Your Ref: OWPC20050
Our Ref: M/92/18/HH 04-07-2018
Please ask for:
Zac Denton

Replacement two storey rear extension, balcony & alterations (resubmission following M/62/17/HH).

2 Elmer Court Elmer Middleton-on-Sea

Drawing No. 1645/2010F

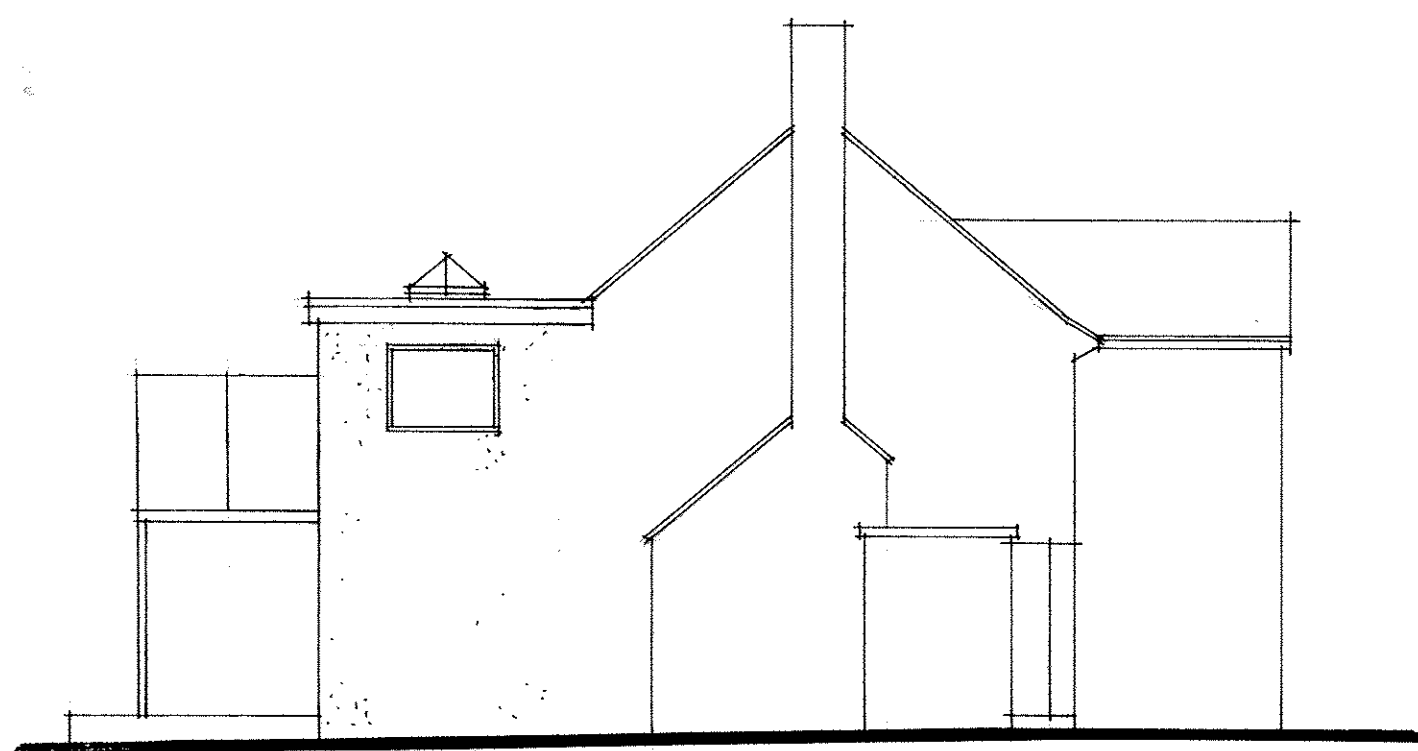
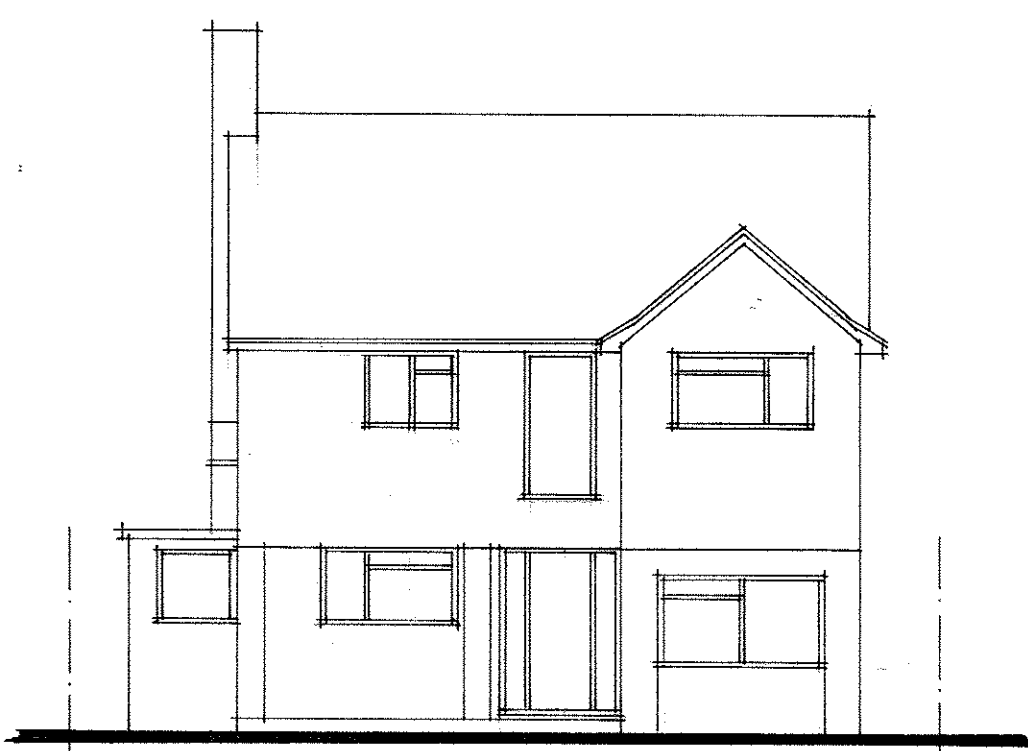
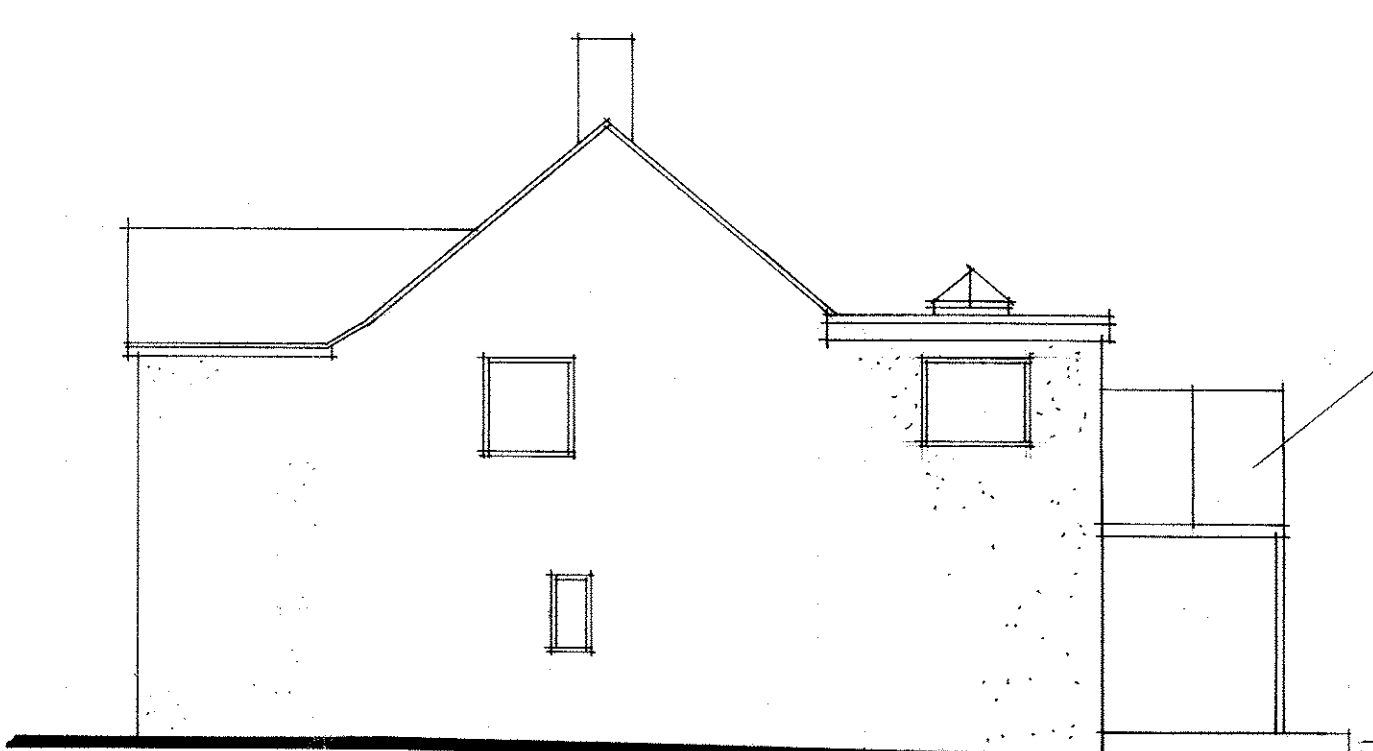
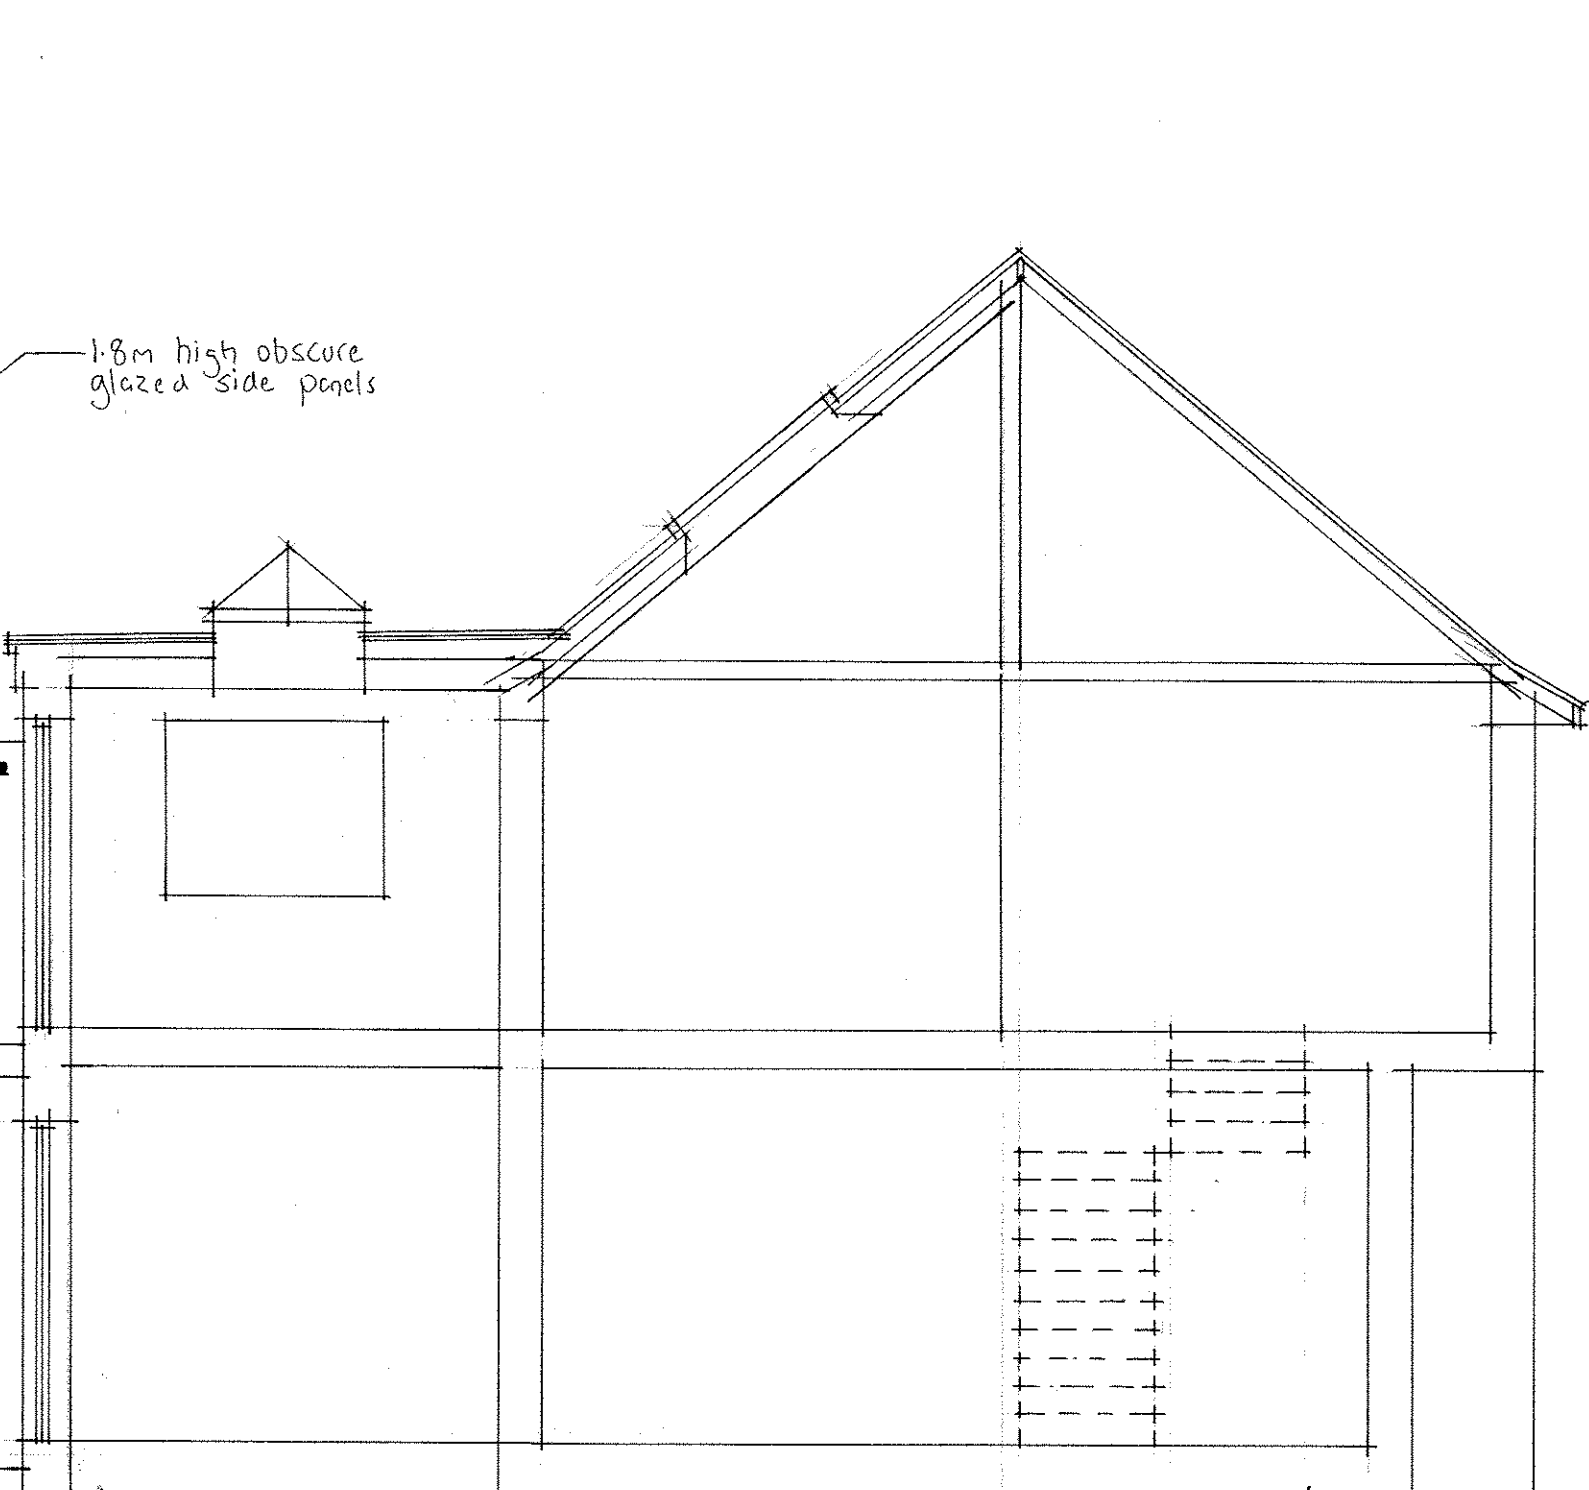
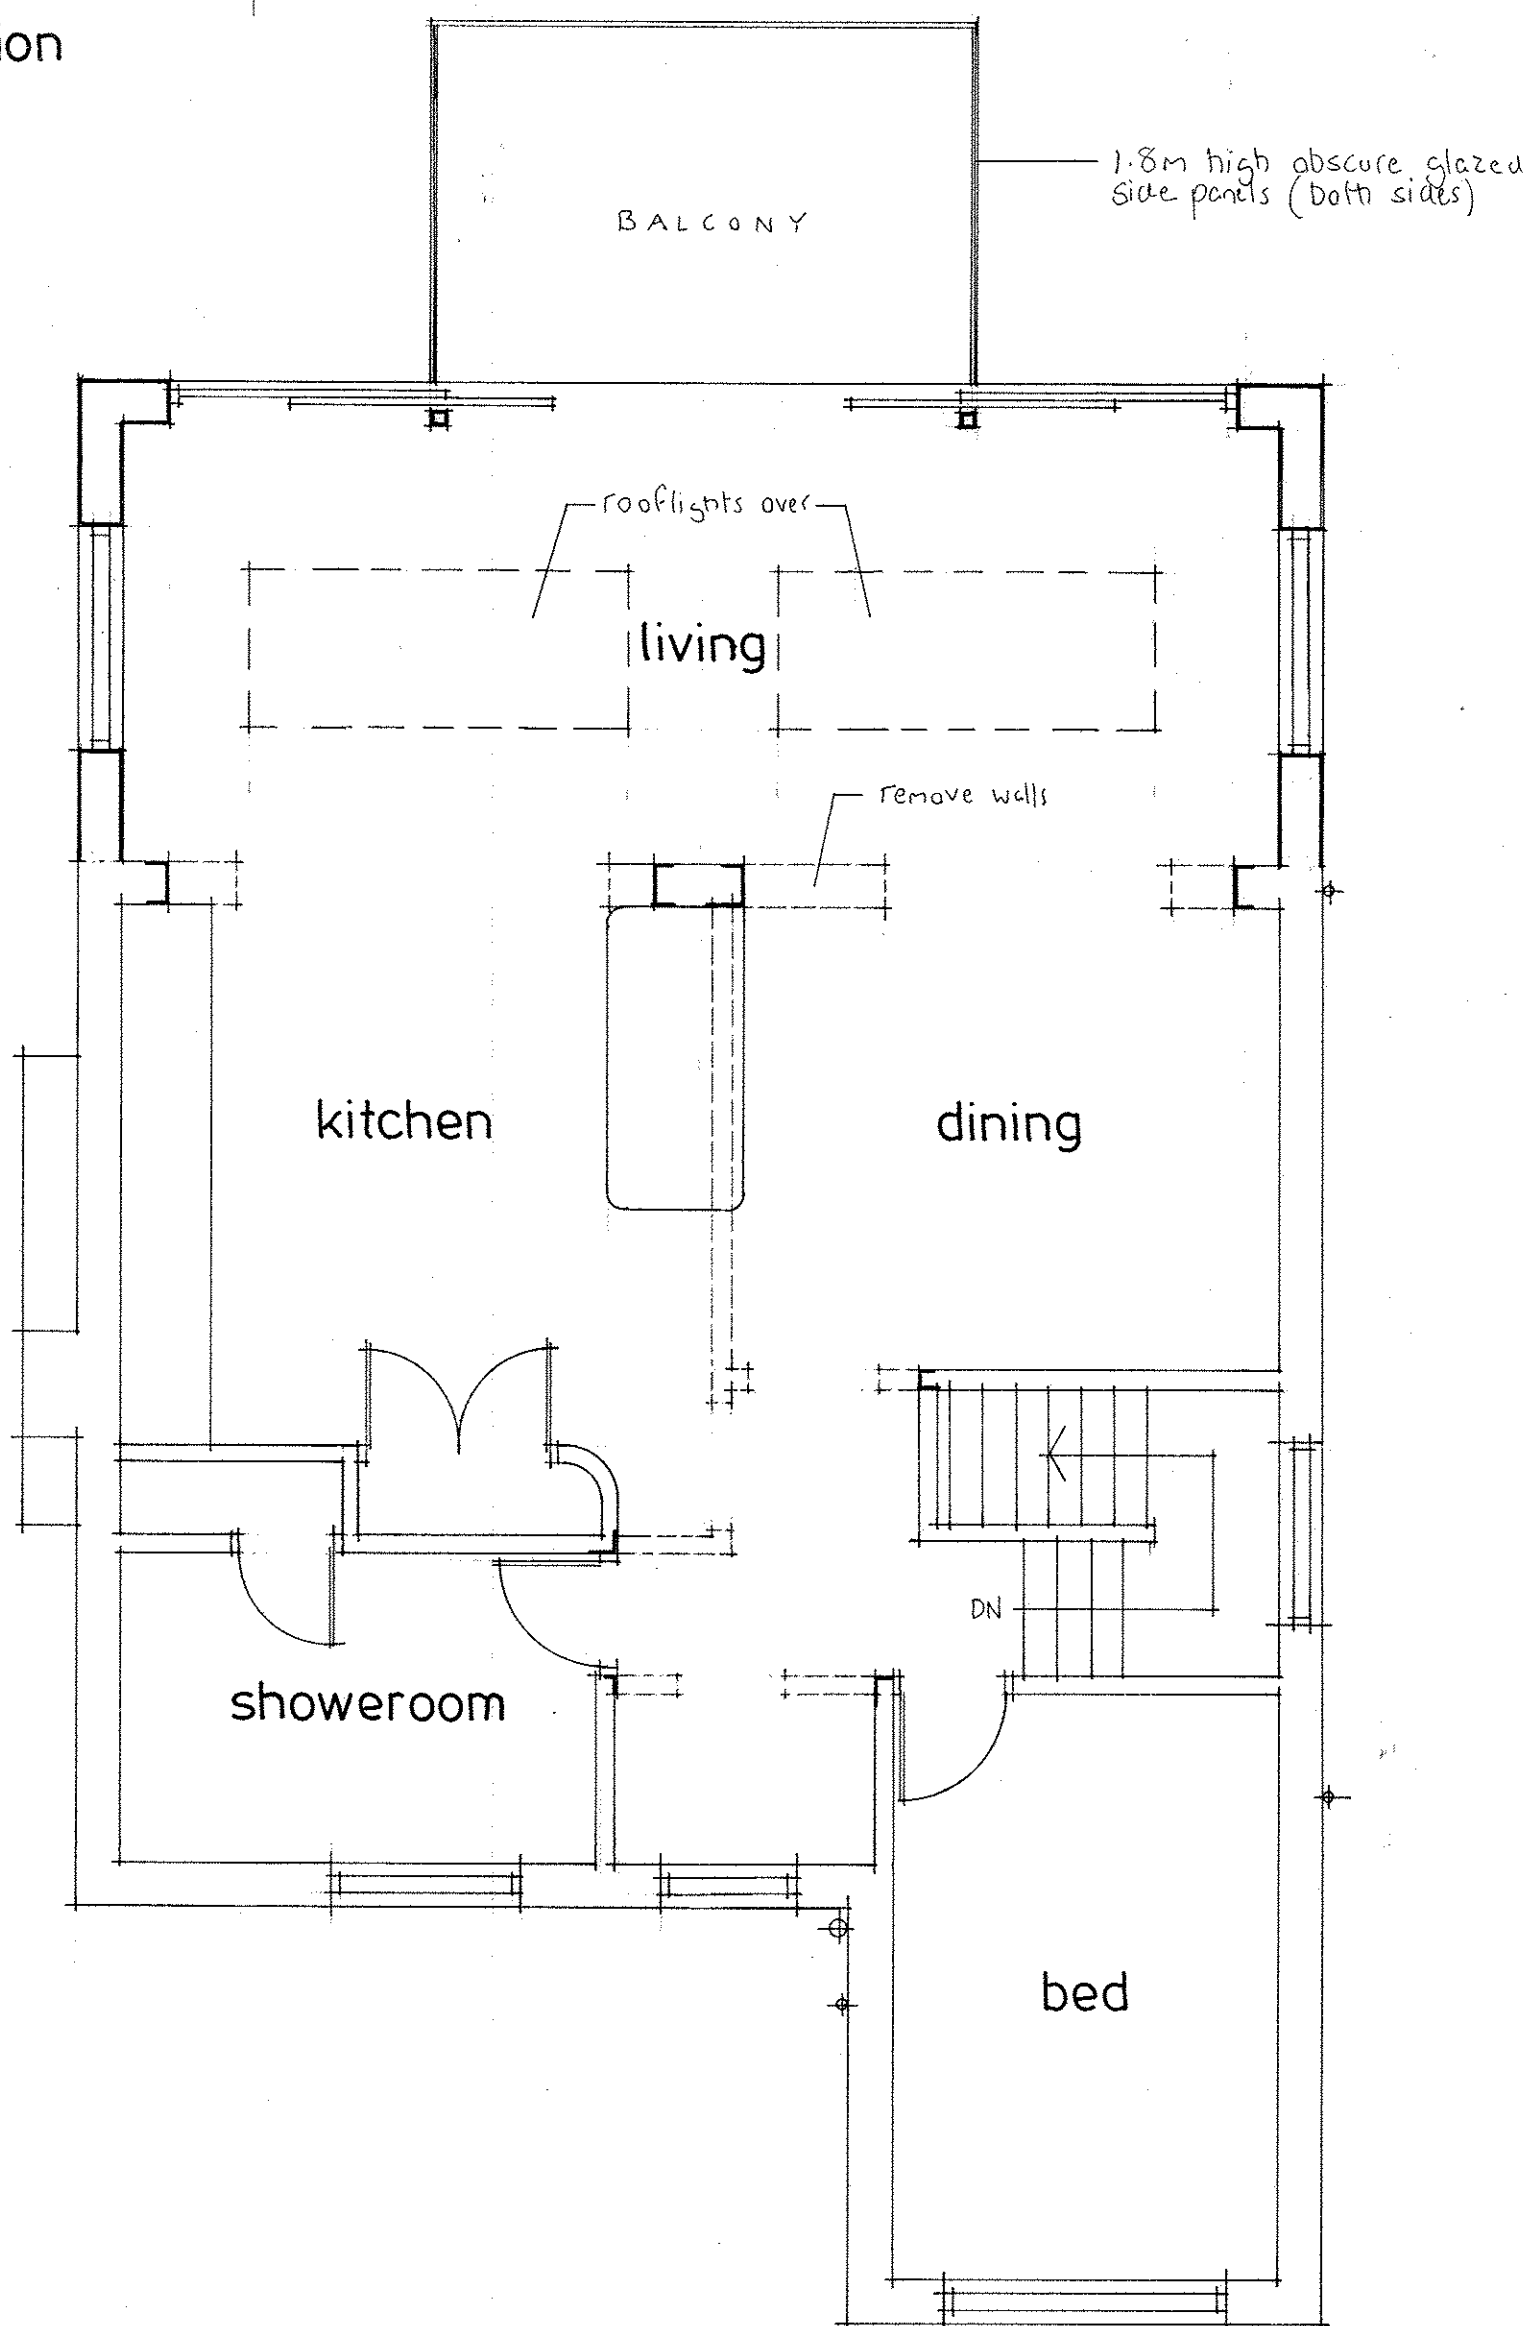
We again need to clarify that the area where there is now a side window was obscured prior to the build (exhibit 1). This is also shown in the picture the owners themselves provided as part of the planning application (exhibit 2).

We have also informed the Council that the side window has moved significantly further towards our windows in comparison to the original plan. This was acknowledged by your planning compliance officer. It is therefore essential to impose the conditions suggested by Mr Jupp as the overlooking has been significantly increased by the build and the Council has now breached our human rights, which needs to be rectified.

Exhibit 1 also shows that there was no render prior to the build and the cladding was not black.. This again shows that the information provided by the applicant is incorrect.
